Cambridgeshire County Council

East Park Energy Project

Planning Inspectorate Reference: EN010141

Written Representation

FIGURE 3 – INDICATIVE DRAINAGE LAYOUT

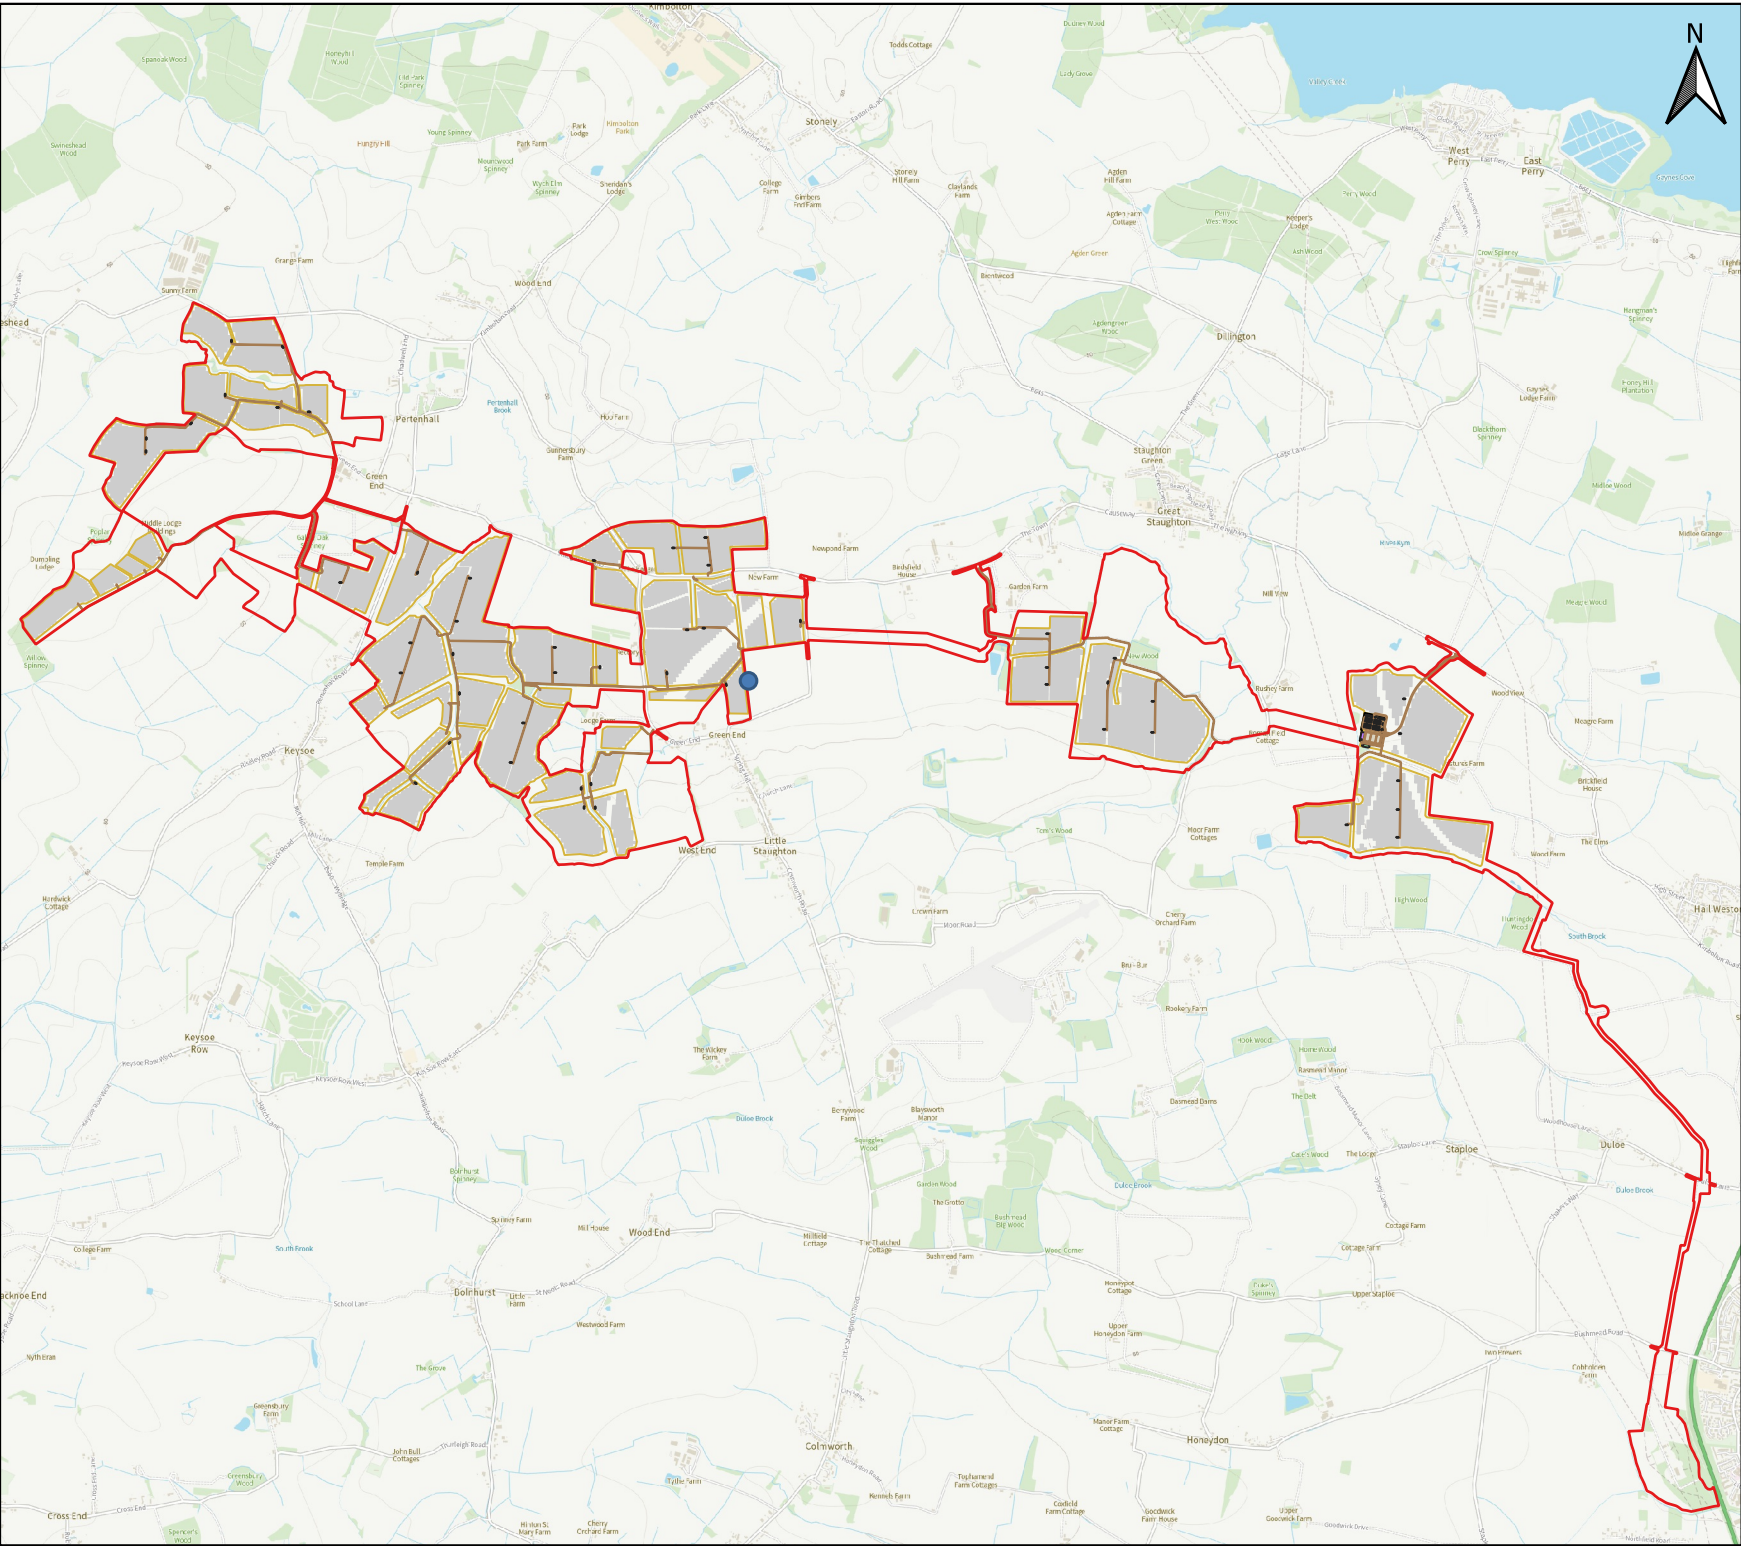
- 5.1 The approach to the drainage strategy is supported in principle, however, insufficient information has been provided to demonstrate that the proposals will not increase flood risk elsewhere. Hydraulic calculations and drainage layouts are asked to be shared before the LLFA is able to confirm the proposals are acceptable with respect to surface water drainage and flood risk.
- 5.2 The council supports culverting being avoided where possible.
